Gatwick Airport Northern Runway Project

Statement of Common Ground Between Gatwick Airport Limited and Environment Agency – Clean Version

VERSION: 3.0

Figure 4.1: Schematic of Museum Field FCA

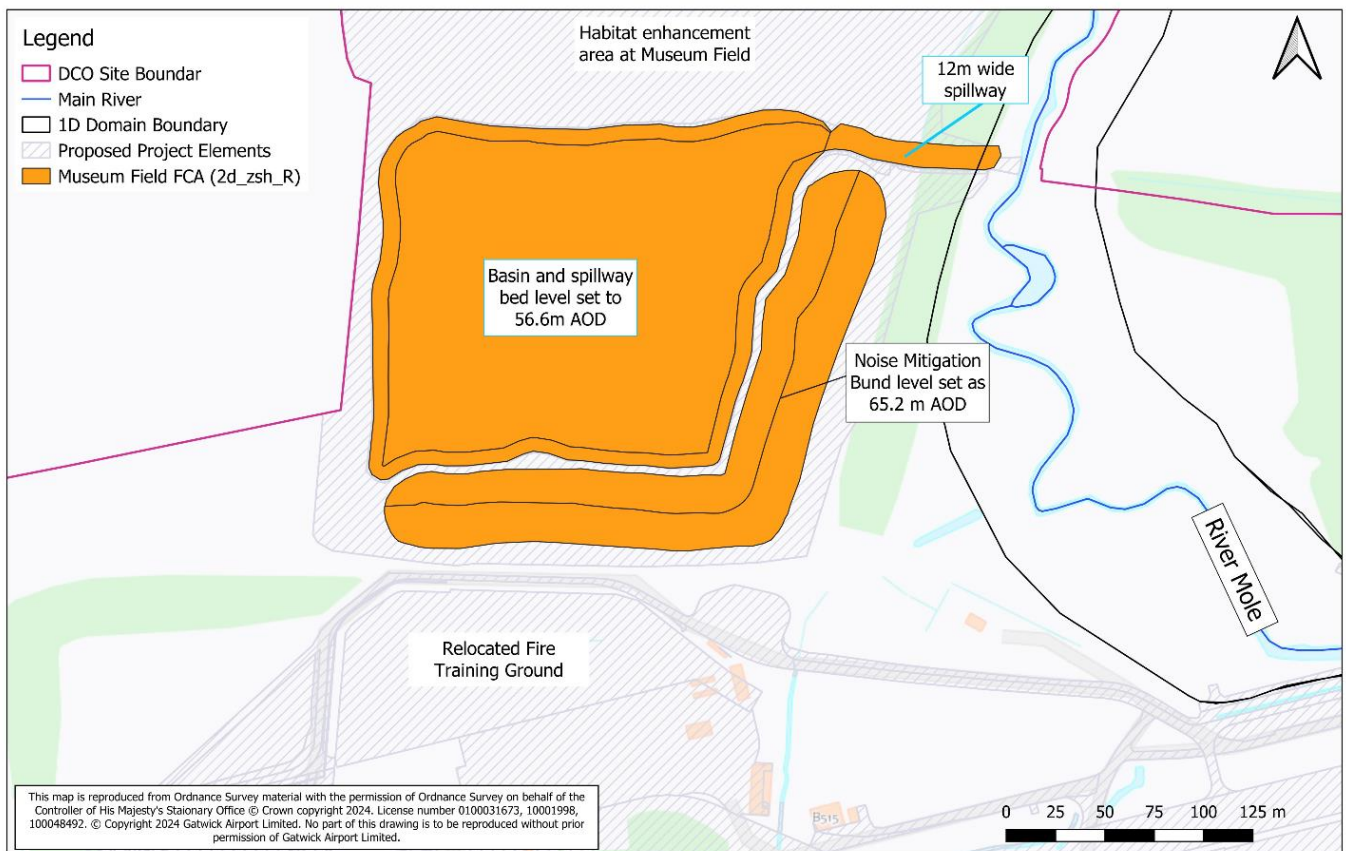
2.8.3.1	Museum field: retaining existing mature habitat where it is compatible with the function of flood compensation area	There are existing mature trees situated within in the Museum Field, which were discussed in a previous joint consultation meeting whether these might be retained and could be assessed for compatibility with the function of that flood compensation feature. The landscaping plans refers to a clear space with new grassland being created within the flood compensation area and note the landscaping design approach which will test the suitability of existing habitat features for incorporation and retention. However, it remains unclear about the fate of these trees within the Museum field flood compensation area, and therefore request clarification. The approach is welcome with established river corridor habitat structures and commitments to protect these sensitive receptors from light pollution at all phases of development.	The flood compensation area has been sized and designed to ensure that the majority of trees that surround the area are retained. The only exception will be a small section on the eastern boundary to facilitate connection to the River Mole. An Arboriculture Impact Assessment and Tree Protection Plan are being produced and will be shared once available.		Agreed
